TO: JIM TSOM, PARRAMATTA CITY COUNCIL

FROM: DON STILL, BEWSHER CONSULTING

DATE: 12 SEPTEMBER 2011

SUBJECT: PART 3A EPA ACT PROJECT, 330 CHURCH STREET PARRAMATTA
ASSESSMENT OF JUNE 2011 SITE FLOOD REPORT

PROJECT
RIVERFRONT APARTMENTS
330 CHURCH STREET
PARRAMATTA NSW
DRAWING NAME
Plan_Level 00 Retail

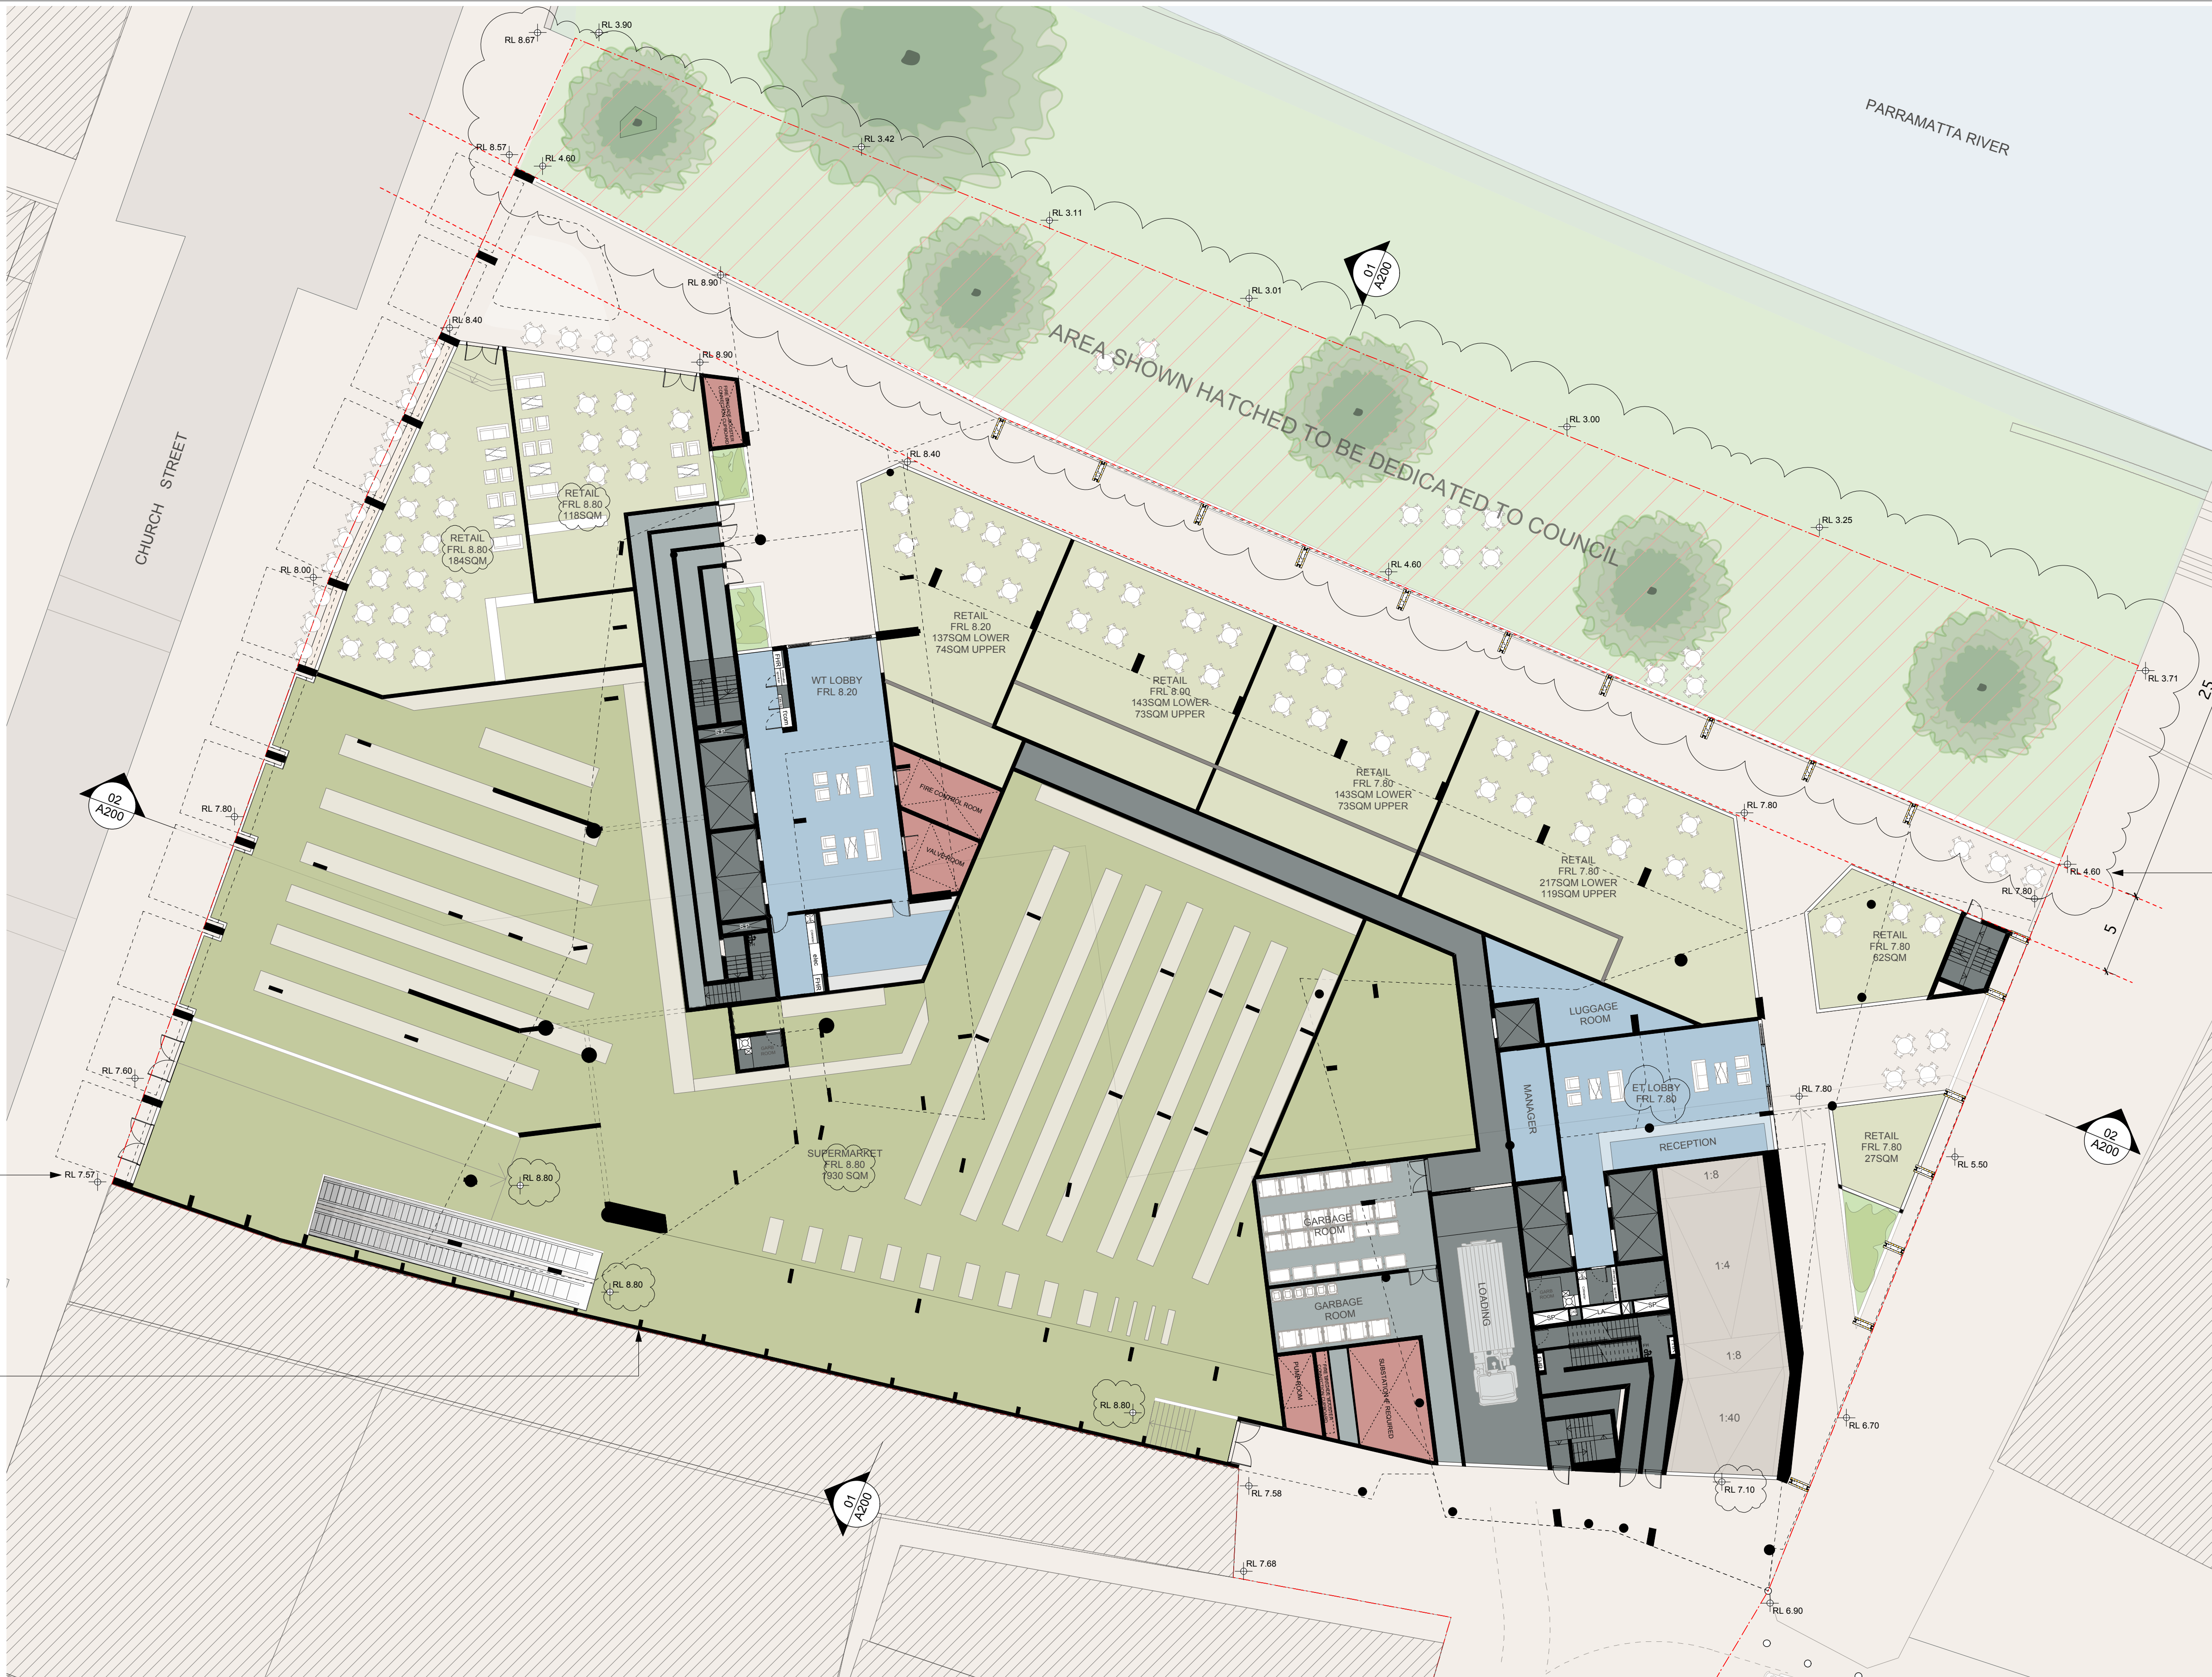
In either case (i.e. adopting a Church Street flood level of 8.0 or 8.4m), the sag point inundation shows that the wall-to-wall Church Street western frontage buildings (which include No. 330) are serving to obstruct the relief of that ponding. Given that the current No. 330 building is immediately adjacent to the sag point, it would seem to be important that the re-development provide some sort of relieving flowpath – by provision of either (i) a surface overland flow path, or (ii) a series of new drainage inlets at the property frontage to Church Street together with receiving conduits, etc which carry the flows under or through the new building footprint.

The report identifies that the proposed basement crest level (of RL 6.95m) is 1.13m higher than the Mott MacDonald-referenced 100 year river level of RL 5.82m.

However it is noted that the basement crest level is proposed to be RL 6.95m and that this is the same as the UPRCT's Phillip Street 100 year flood levels. Hence the Phillip Street-sourced flood regime immediately adjacent to the site needs to be formally modelled if the currently proposed crest level is intended to be retained.
